MEMORANDUM

TO: Nell Donaldson, Planner
FROM: David Senus, PE
DATE: January 8, 2016
RE: 65 Munjoy Street, Final Level III Site Plan Application

Woodard & Curran has reviewed the Final Level III Site Plan Application for the proposed 8-unit condominium located at 65 Munjoy Street in Portland, Maine. The project involves the construction of an 8-unit condominium building to be constructed on an existing paved parking lot area.

RETAINING WALL DETAIL AT SPILLWAY TO RAIN GARDEN
NOT TO SCALE

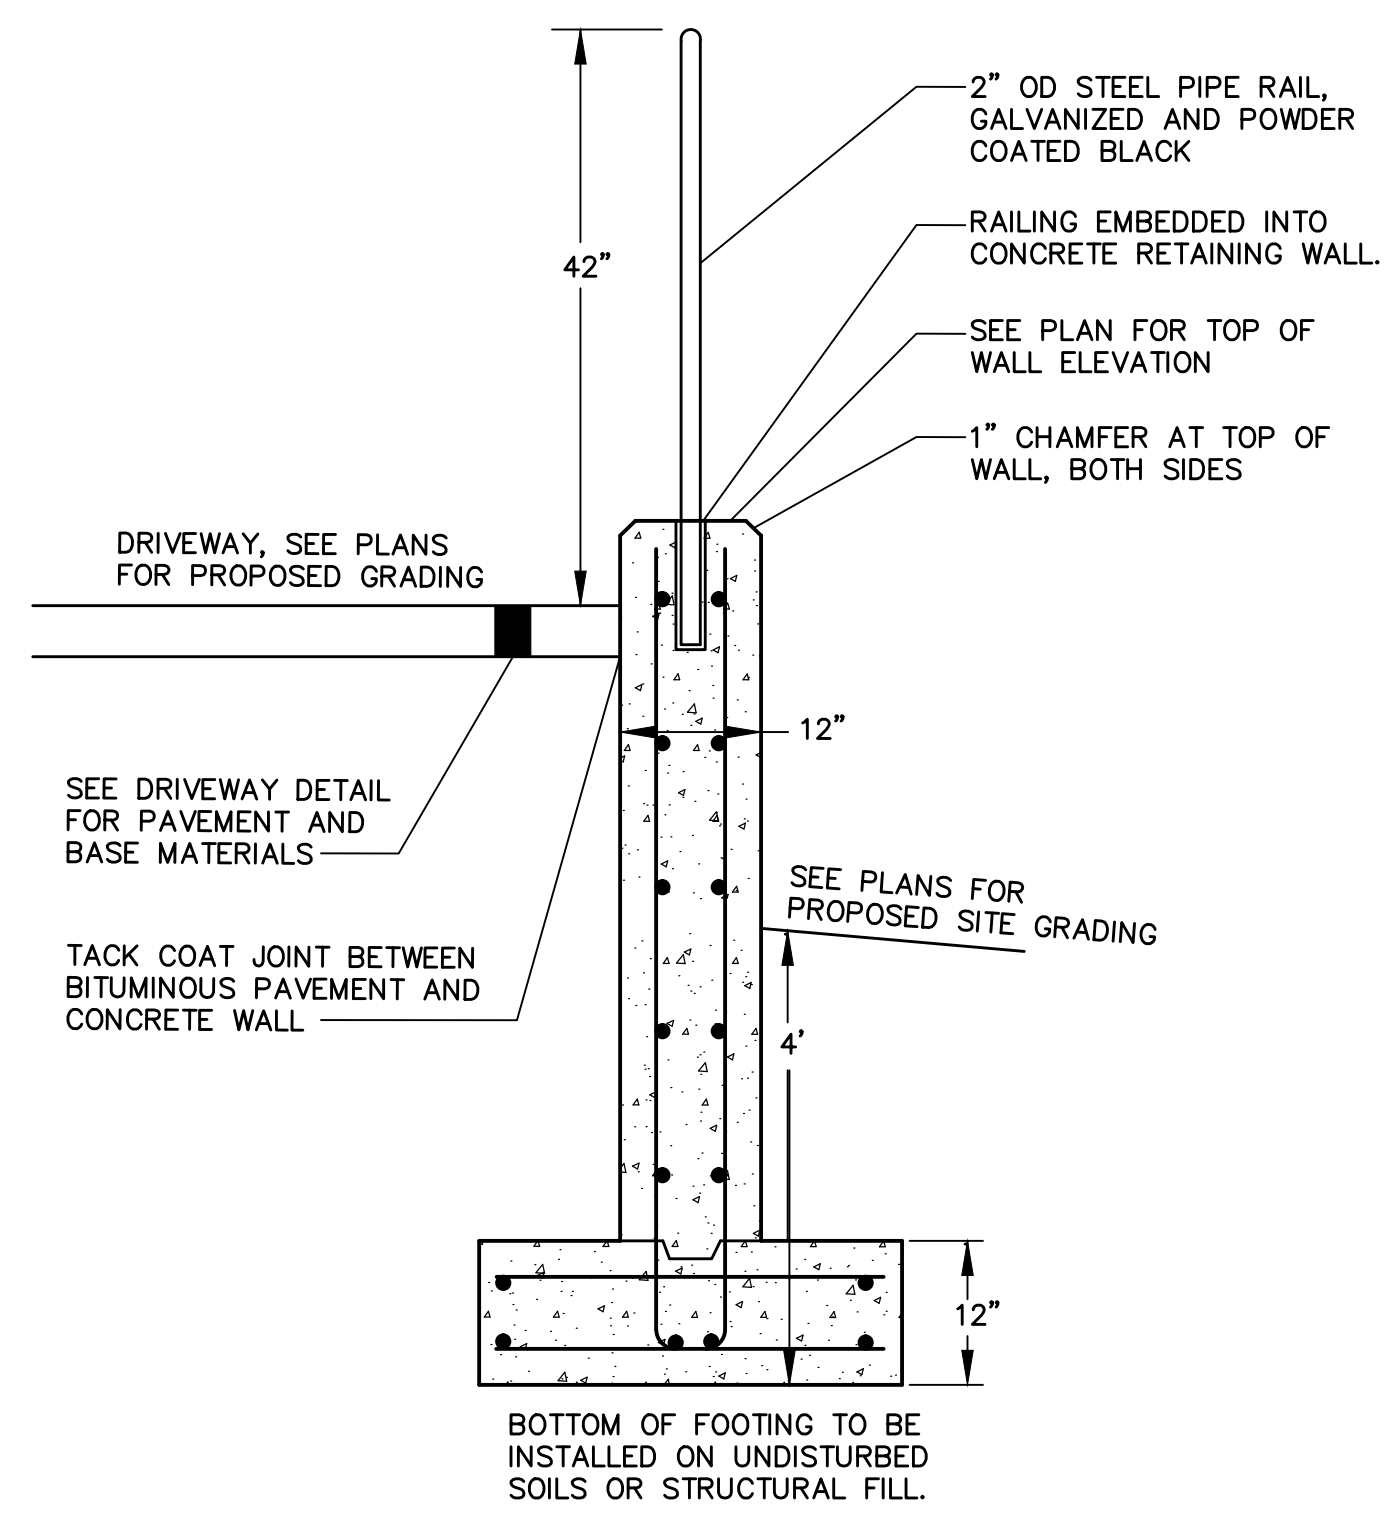
- 4) Runoff from the driveway area will enter a raingarden that is situated approximately 2.5' lower in elevation than the adjacent driveway grade through a break in a retaining wall. A detail should be provided to show the interface of the wall/inlet into the raingarden.
- 5) A detail should be provided for the proposed retaining wall.
- 6) The intent of having a "swale" within the tree lined vegetated strip between the driveway and the western property edge is unclear. The tree plantings in this location and snow storage is likely to impede drainage.
- 7) Pavement saw cut lines should be shown for the utility connections within Munjoy Street.
- 8) As noted on the plans, additional coordination is needed to re-route overhead utilities that cross the property to provide service to the adjacent, abutting properties.

**CONNECTION TO SANITARY SEWER**  
NOT TO SCALE

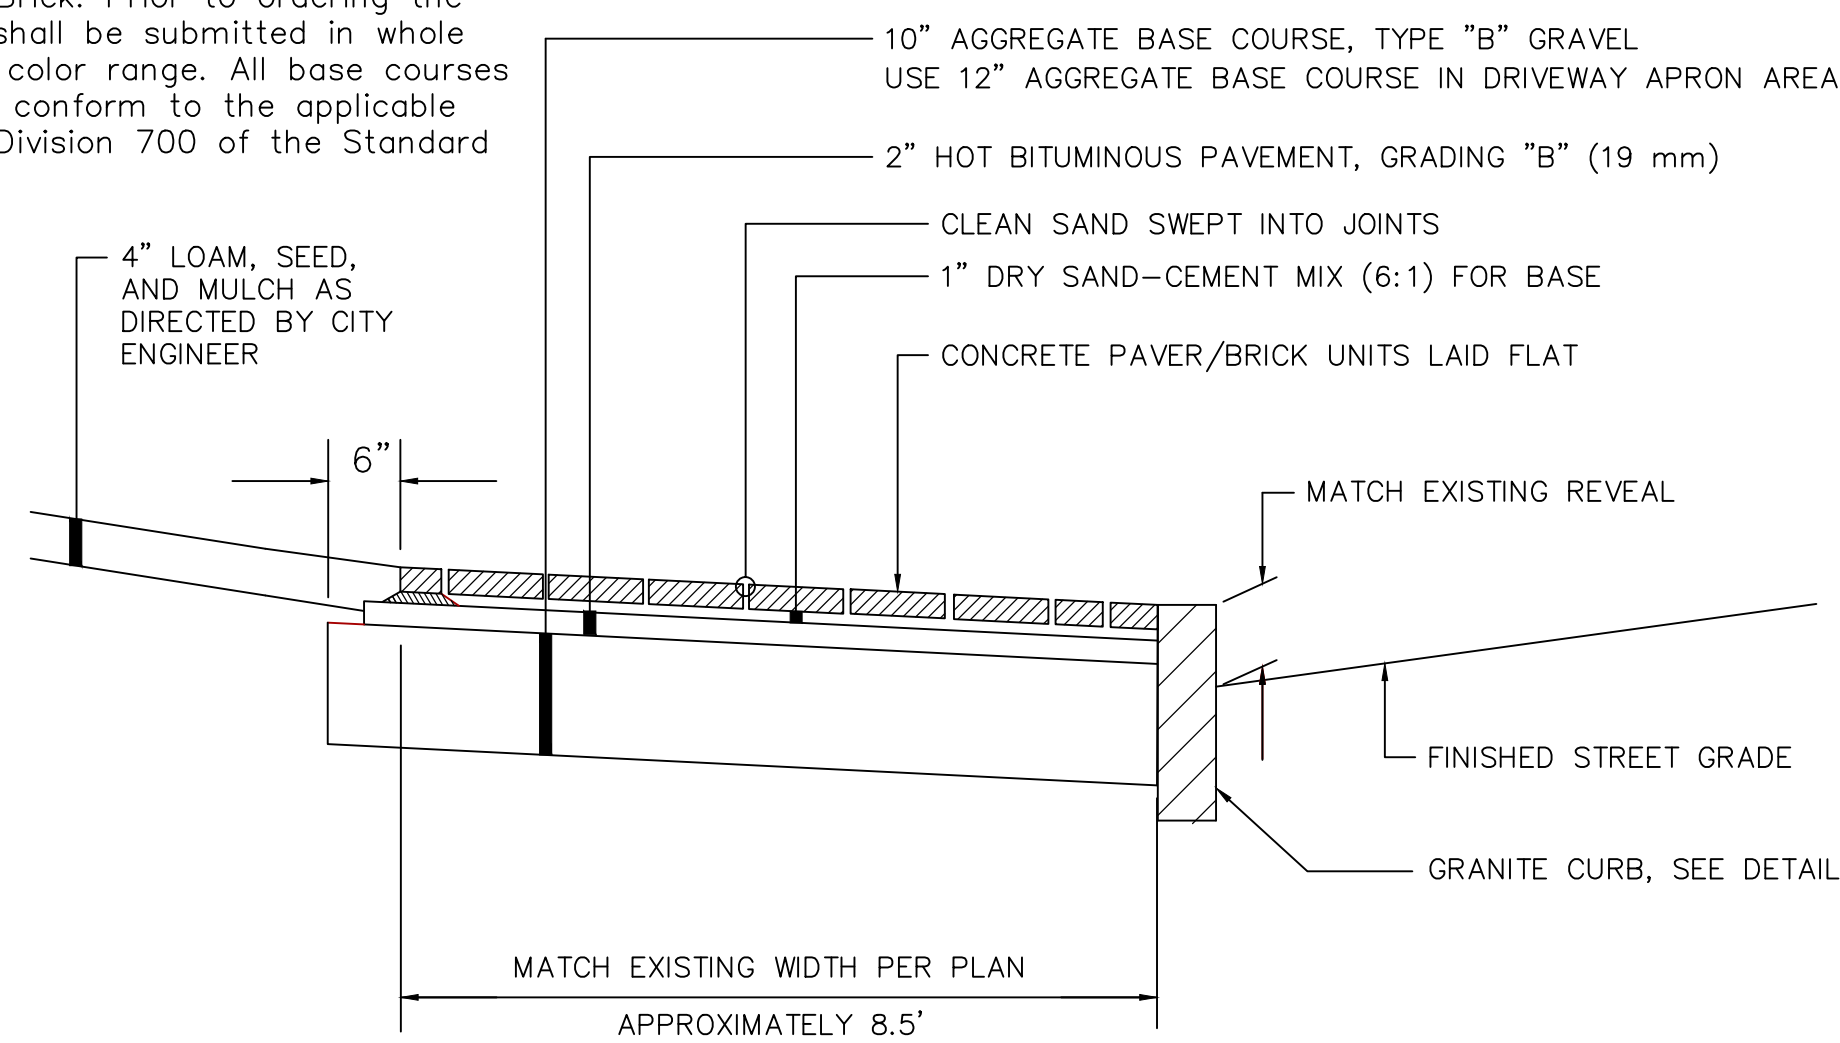
- 3) In accordance with Section 2.6.9 of the City's Technical Manual, all new (sewer) laterals connecting to a combined sewer system shall have a back water valve. The back water valve should be located on private property and a detail should be provided.
